Appeal Decision

Appeal Ref: APP/R4408/D/21/3288840

8 Vicar Crescent, Darfield, Barnsley S73 9LB

- The appeal is made under section 78 of the Town and Country Planning Act 1990 against a refusal to grant planning permission.
 - The appeal is made by Mr Anthony Foster against the decision of Barnsley Metropolitan Borough Council.
 - The application Ref 2021/1266, dated 15 September 2021, was refused by notice dated 23 November 2021.
 - The development proposed is a boundary wall and fence.
-

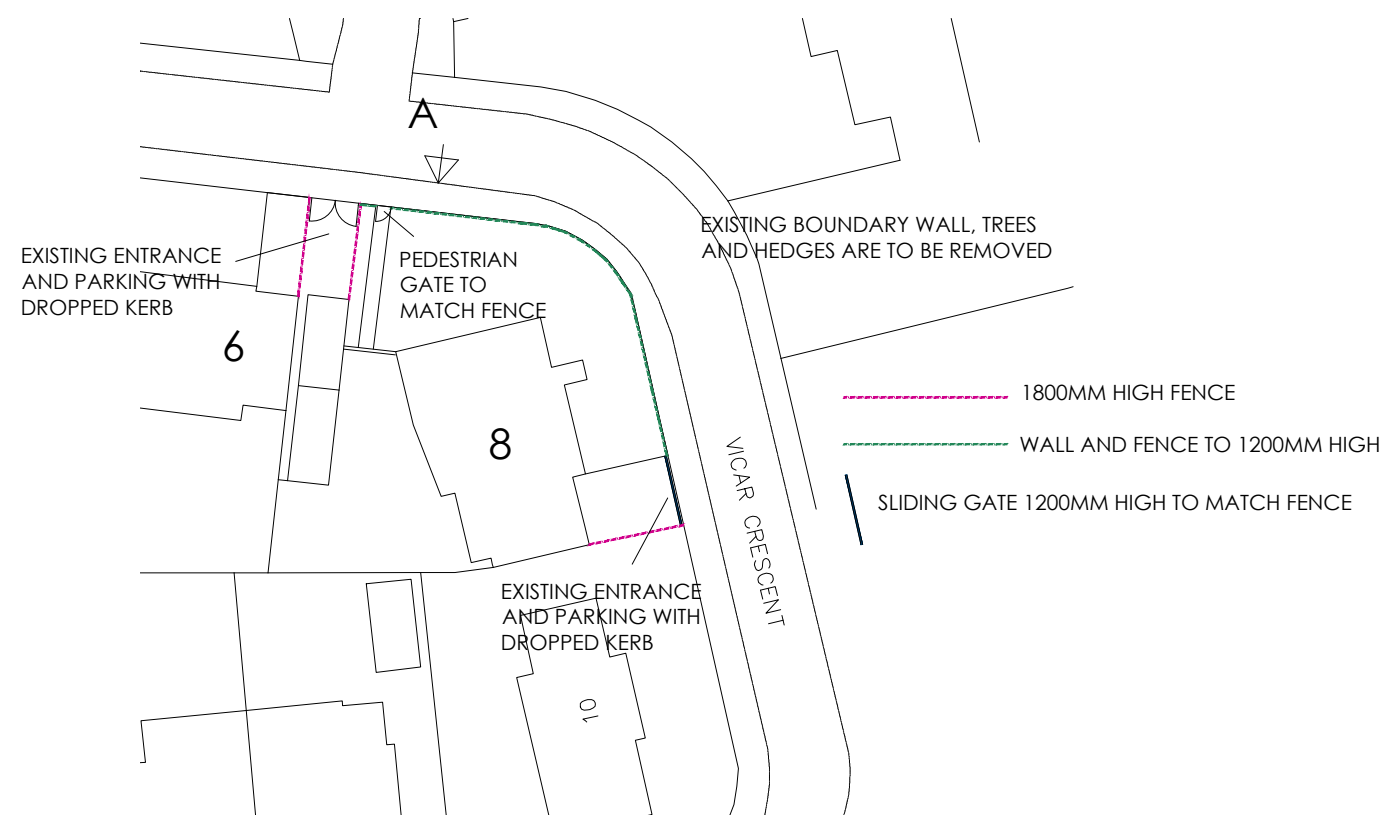
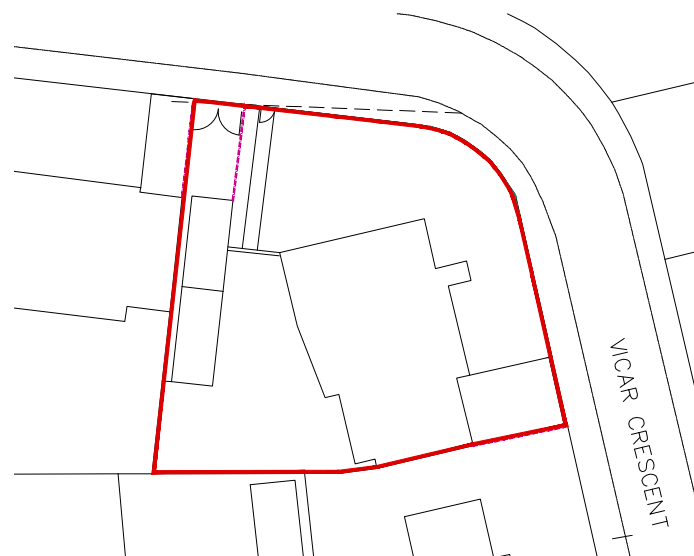
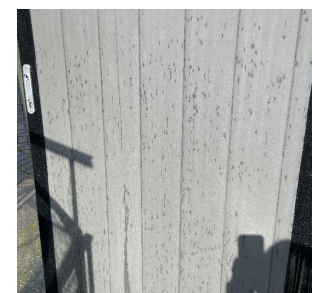
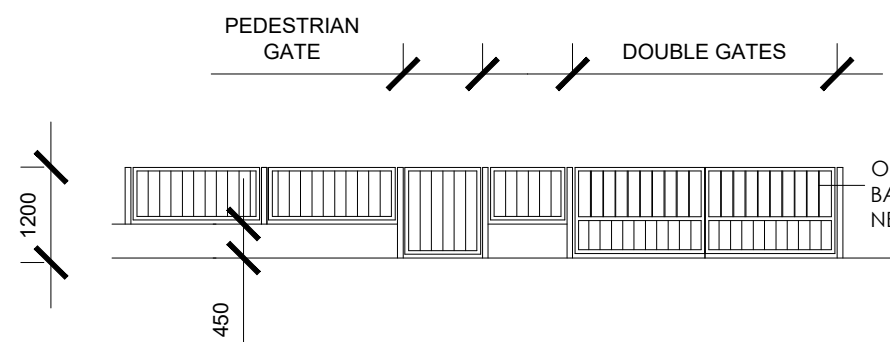
4. The proposal seeks to erect a combined wall and fence to an overall height of 1200mm along the boundary with the highway, along with a pedestrian gate and sliding gate for vehicular access. It also includes the introduction of fencing to the front sections of the side boundaries of the property (and the eastern side of the parking bay adjacent to No. 6 Vicar Crescent) at a height of 1800mm.

5. The wall and fencing proposed to the front boundary is of a height and type which is not commonly found within Vicar Crescent. It would be noticeably taller than the majority of the other walls and fencing within the road and it would appear out of keeping as a result. One element of the proposed 1.8m
-

fencing would either replace or supplement a tall wall which runs along the front section of the boundary with No. 10 Vicar Crescent, but the fencing which would be introduced either side of the parking bay adjacent to No. 6 Vicar Crescent would have a further enclosing effect and would harm the open character of the street. The harmful visual effect of the proposed forms of boundary treatment would be exacerbated by the prominent position of the appeal property on a bend in the street scene.

7. The appeal property has two points of vehicular access; one at each end of its frontage. The parking space at the north-western end of the frontage is only a short distance from the bend in the highway. The installation of 1.8 metre high fencing along the eastern side of the associated parking space would harmfully reduce the current levels of visibility looking eastwards towards the bend. Given the presence of the tall wall which runs along the front section of the side boundary shared with No. 10 Vicar Crescent, the proposed 1.8 metre fencing in this position would not materially worsen visibility in the southerly direction. Nevertheless, the 1.2 metre tall wall and fencing along the frontage would reduce visibility from the southerly access point in the direction of the bend, which again, is only a short distance away. Furthermore, the proposal would increase the danger for pedestrians, particularly small children, who would be less visible to motorists exiting either access at the appeal property.
